Submission No.			089	
Organisation Name or Name of Submitter			Estuary Court Residents Association (16 Estuary Court, Swords), Submission No 2 (prepared by Barry Arthurs)

Item No.	Section Ref.	Page No.	Observation Statement	TII Response
Letter Re: Railway (MetroLink-Estuary to Charlemont via Dublin Airport) Order 2022, Estuary Court Submission No. 2- Short and Long Term Impacts of the Proposed MetroLink Route Through Estuary Court				
1	Cover letter	1	The submission sets out genuine concerns for the residents in Estuary Court. We understand for a large infrastructure project like the Metrolink, there will always be an amount of disruption however, we believe under the current proposal, Estuary Court will suffer an unproportional amount of disruption and also an enduring impact with the proposed linear park. We would be grateful if you would consider our submission favourably.	TII welcome your input and responses are provided below.
2	Cover letter	1	We welcome any questions you may have and would also so welcome the opportunity to represent the Estuary Court residents at an oral hearing.	TII are happy to continue to engage with residents up to and during the Oral Hearing to attempt

Project	Drawing Title	Drawing Status
Estuary - Seatown Landscape Layout Preliminary Design Issue		S4
Drawing N°	ML1-JAI-ARL-SC01_XX-DR-Y-00001	
Scales Original Size A1	1:1000	Sheet 1 of 3

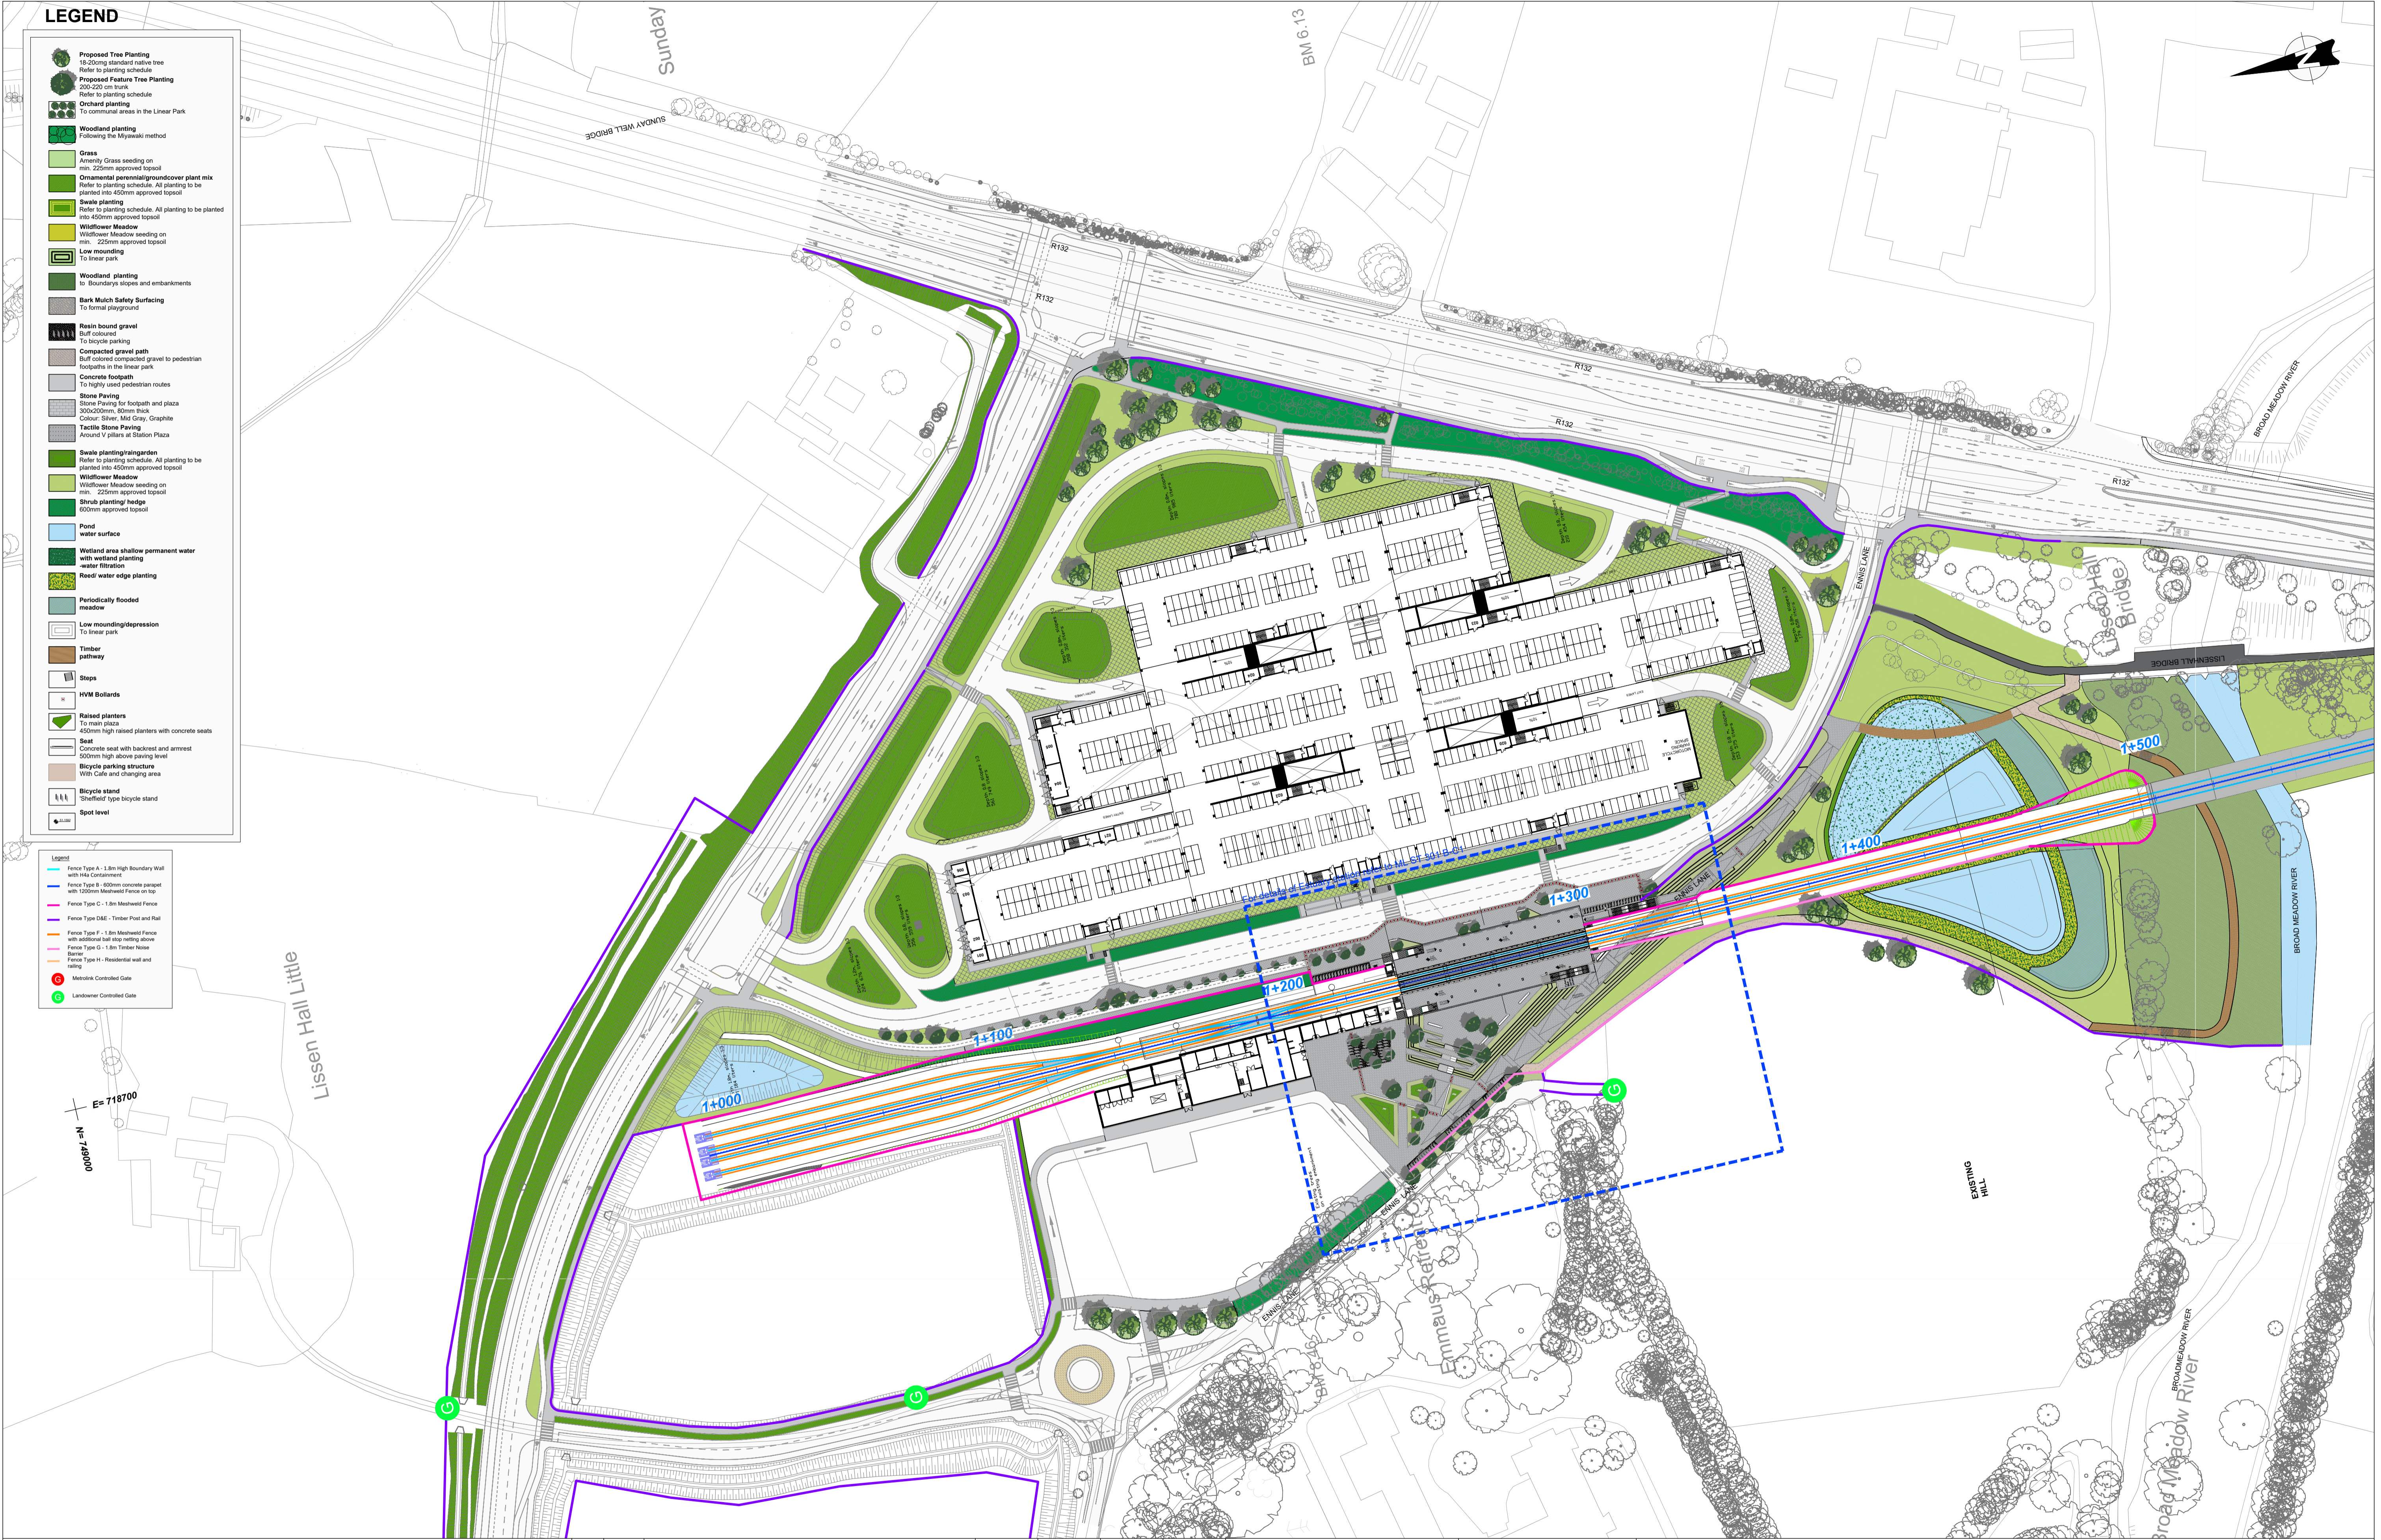
8	3. TII Proposal	16	We believe it is not fair or reasonable to take away both of our open green spaces. The bottom green is planned to be used by TII as a satellite compound. We believe not enough consideration has been given to the impact this will have on the residents of Estuary Court and it seems like TII have gone with the easy option to take what they can. There is a large satellite compound already planned for Woodies car park which is only a few meters from Estuary Court and there is an alternative option with the Fingal Co. Co. car park very close to Estuary Court that could easily accommodate the requirements above for a satellite compound. Please see Fig 3.1 of the submission.	See response number (5) above.

11	3.2 Permeability	20 and 21	As mentioned above, none of the residents in Estuary Court want additional access points in the boundary wall or paths through our greens and as there is no through access to other areas from our estate, we can’t understand the logic behind this proposed design. When we queried this with the TII, their answer was ‘permeability’. We understand permeability in an urban design context to mean ‘the ease of movement of people to encourage walking or cycling’. This sounds great in principle however, there is a negative side to permeability and studies have linked higher property crime rates to it and found that the over-provision of poorly used permeability is a crime hazard. Another negative impact with Permeability is anti-social behaviour. Highfields Estate in Swords successfully campaigned to Fingal Co. Co. to close access points in their estate due to anti-social behaviour.	See response number (9) above, with Anti-social behaviour also addressed in response number (3).

13	3.3 Public Linear Park	23	After the Metrolink construction works are complete, the TII are proposing to subsume the open green spaces that the residents of Estuary Court have enjoyed and used for over 30 years into a public linear park. When we first met the TII (Feb 2021) their original plan was not to reinstate our boundary wall so our greens would open out to the R132 and be landscaped with shrubs and trees and form part of a public linear park. As mentioned above, they have now agreed to reinstate a wall (fence type H - design to be confirmed) however, they still want to change our open green spaces to form part of the linear park with shrubs and trees and paths running through it. While this sounds lovely and looks good on a drawing, it would only leave an open green strip approximately 15m wide at the bottom green running along the estate road. This would be completely unsuitable for any type of ball games to be played here. We note that Section 7.5. 6.4 of the Non-Technical Summary sets out that <i>where possible, all playing pitches that are impacted during the Construction Phase</i> will be reinstated with improved facilities following completion of the Construction Phase. We find it unacceptable that the TII will reinstate playing pitches with improved facilities however, they won’t even reinstate our small open play areas that are so essential to all residents, particularly children and pet owners.	See response number (3) above.
